Planning Application Ref: M/135/21/T

Location: 16 Ancton Way, Elmer, Middleton-On-Sea, PO22 6JN

Description of works: Reduce overhang of 2no. sycamores by 3m to leave 2m

REF 1

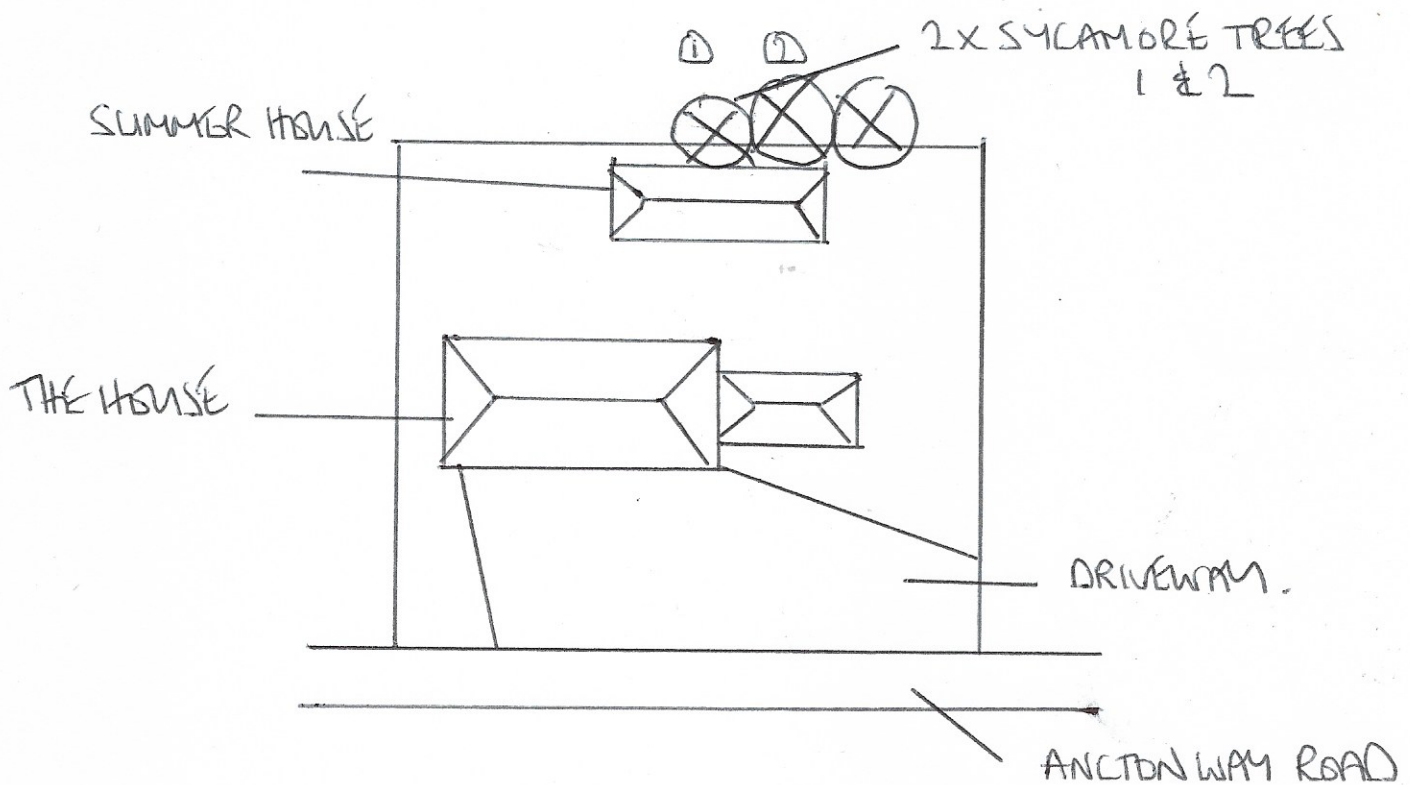
T1 & T2 Sycamore / *Acer pseudoplatanus* Height: 10-15m, Radial spread: 0-5m, Age class: Early mature

- Outwardly and from a distance (roadside) these trees appear to be in a fair physiological state and assumed to be so in the absence of any evidence provided to the contrary. They form a cohesive pair.
- They are woodland fringe trees, protected by a Tree Preservation Order. This work proposal will result in relatively discreet pruning being carried out and not alter the fundamental character of the woodland.
- The trees grow at the rear of the property but can be clearly seen from neighbouring dwellings and in part from publicly accessible land.

- The work proposed is justified on arboricultural grounds as it seeks to maintain reasonable clearance from adjacent residential property.
- There will be no loss of public amenity on completion of the proposed works.

- I recommend **CONSENT** for this application, subject to the following condition:

Part a) Where whole branches are to be removed and final cuts made close to the trunk or branch union they are to be made as shown in Figure 2 of BS3998:2010

Part b) Where branches are to be shortened back the final cuts are to be made at the correct angle shown in BS3998:2010 and adjacent to a live bud or lateral.
